OUT21/16369

**155-217 Aldington Road Estate (SSD-17552047)  
EIS**

Liz Rogers  
Manager, Assessments, Knowledge Division  
**Department of Planning, Industry and Environment: Water**  
21 December 2021

Status	SSD APPROVAL NOT FOR CONSTRUCTION	A1
Project - Drawing No.	20-776-C1035	Issue
		C

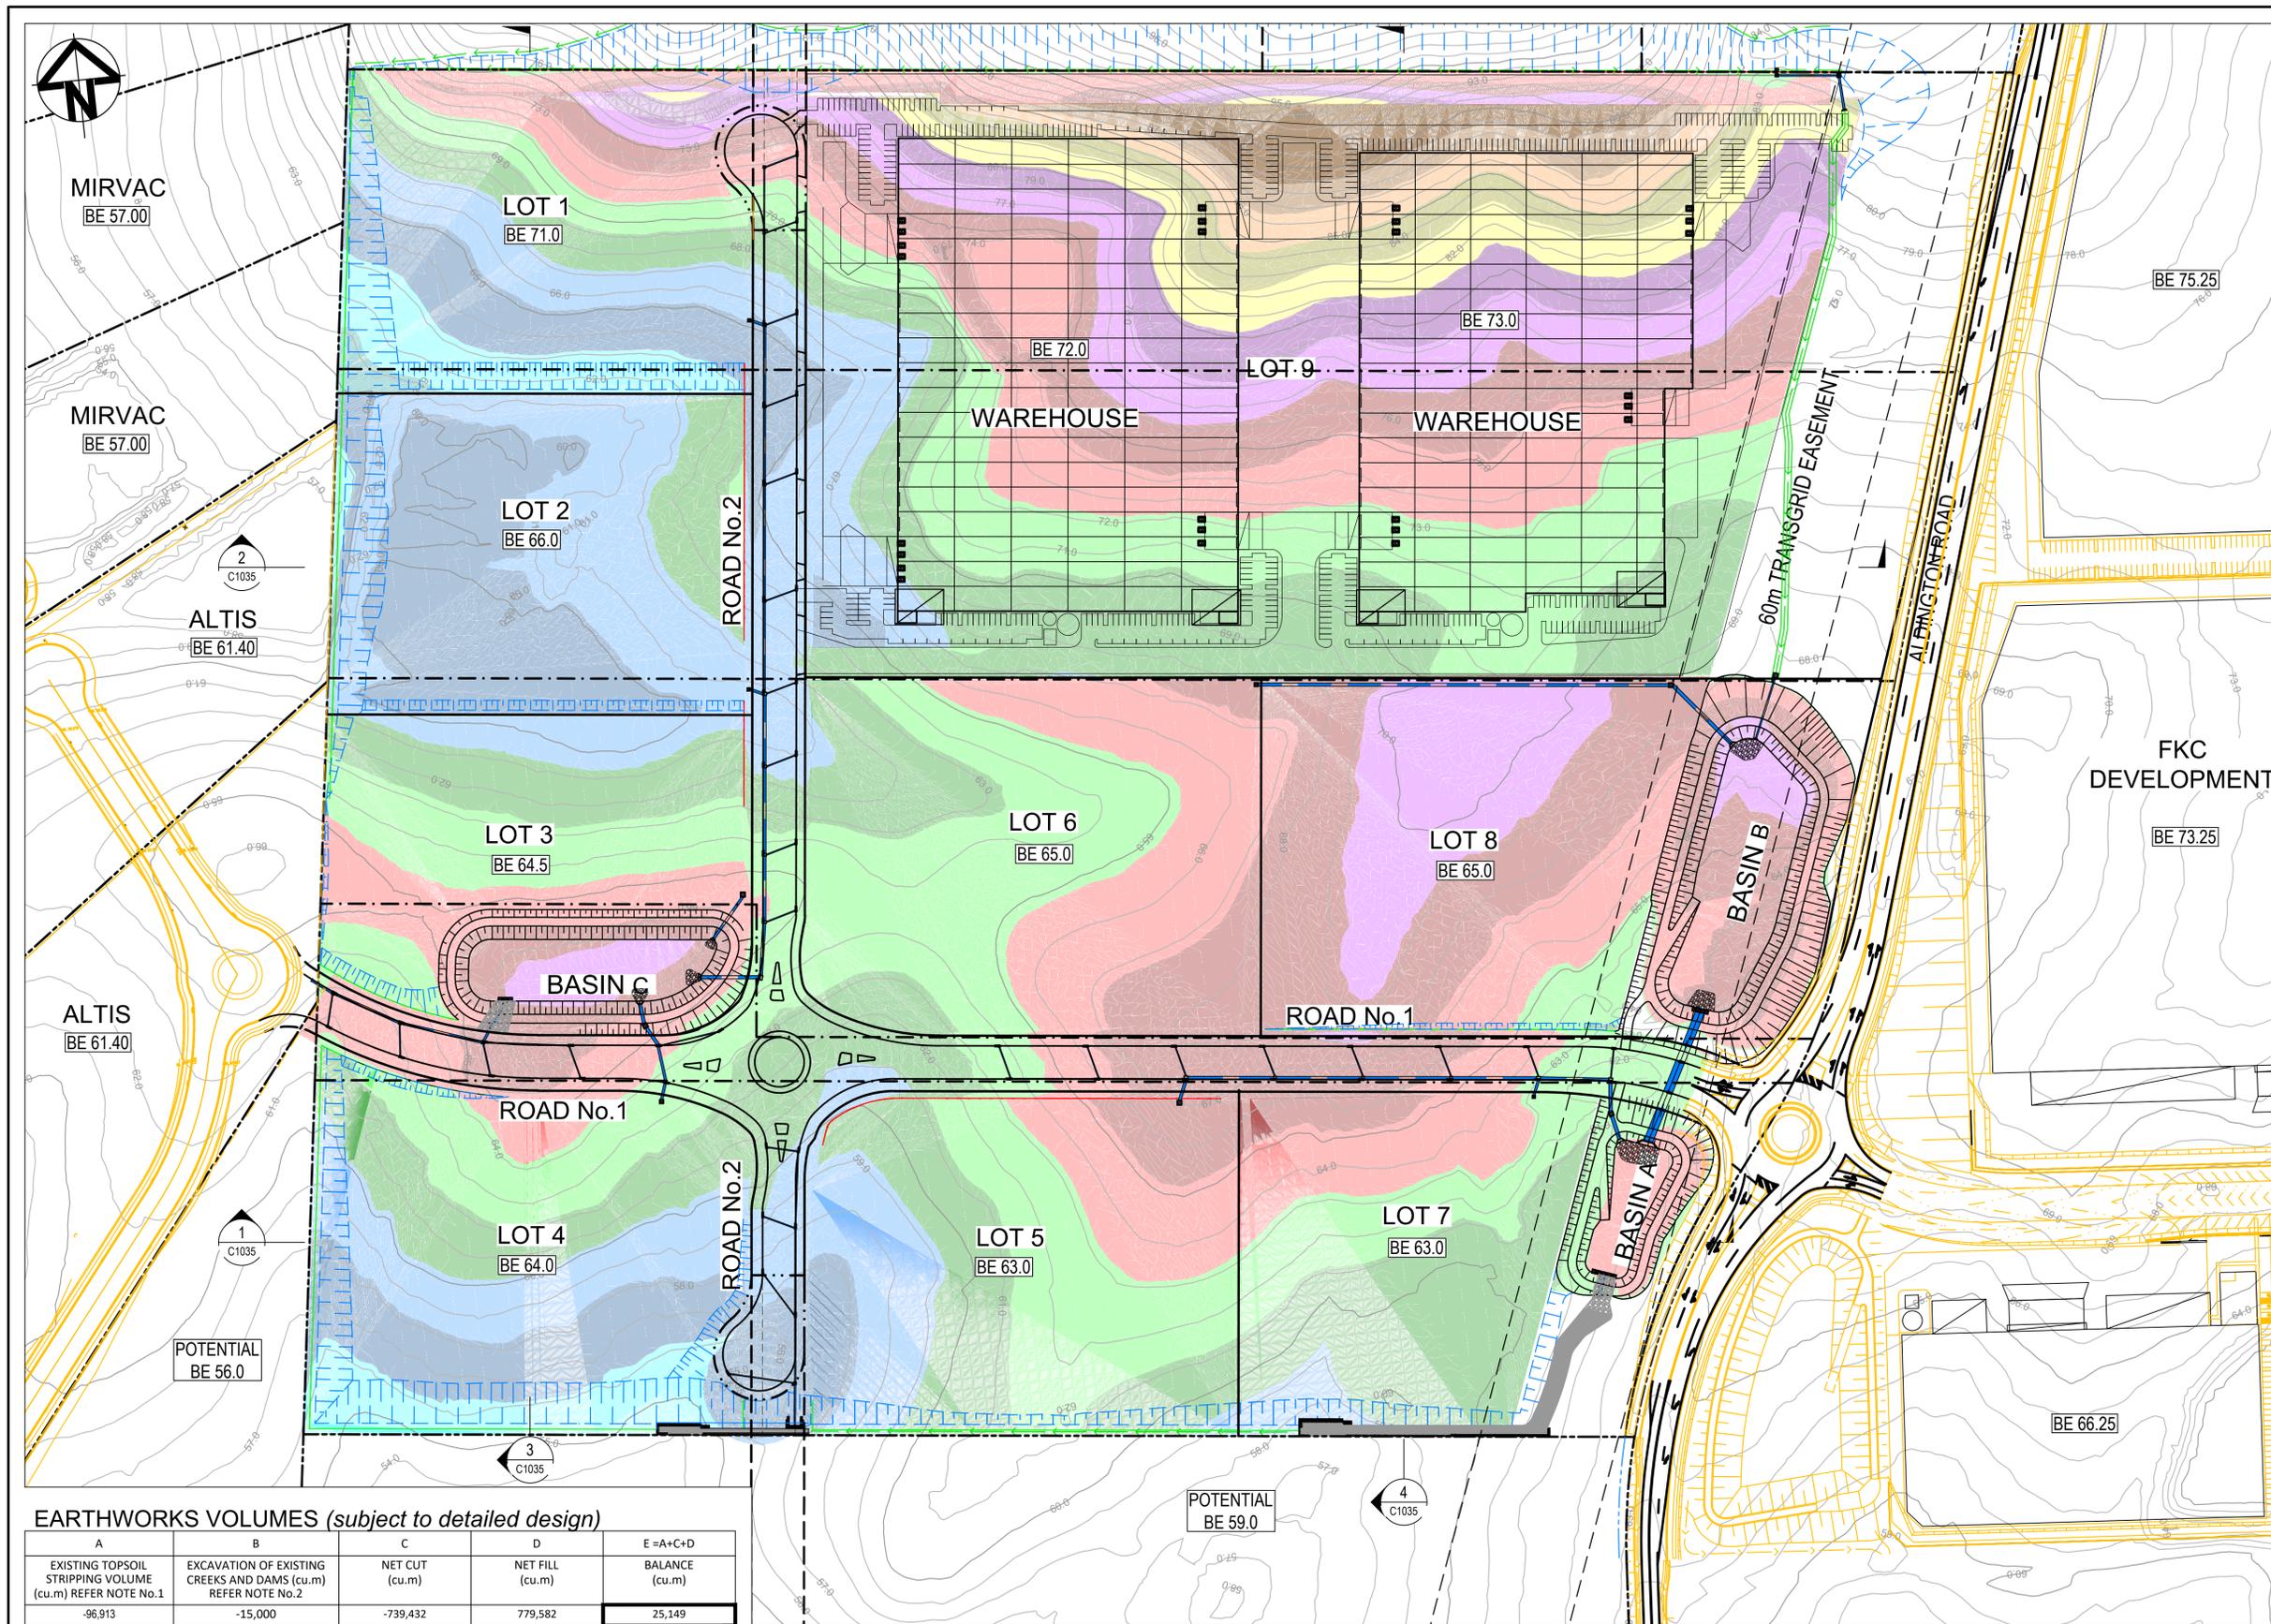
1. Confirm whether groundwater will be intercepted due to the depth of earthworks particularly along the northern boundary which shows a cut depth of up to 16m.

Explanation- The EIS states that from the test pits and auger holes there were no groundwater inflows (page 124 of the EIS). This is the only information provided on groundwater. Appendix 28 – Geotechnical Report shows in table 4 (page 6, pdf 6) that the depths of test pits were at a maximum of 5m below surface level but generally were closer to 1-3m in depth. As there are cut levels to 16m as shown in Appendix 20 – Civil Plans, plan 20-776-C1030 Issue C, we require clarification whether groundwater will be intercepted at that depth.

2. Quantify the maximum annual water take in accordance with the requirements of the NSW Aquifer Interference Policy if groundwater is to be intercepted. The proponent should demonstrate that any required groundwater entitlements can be obtained from the water source for the predicted groundwater dewatering.

Explanation- The works would be in the Greater Metropolitan Region Groundwater Sources 2011, Sydney basin Central Groundwater Source. This source is currently over allocated with 2,592 unit shares made available and 4,029.5 shares assigned.
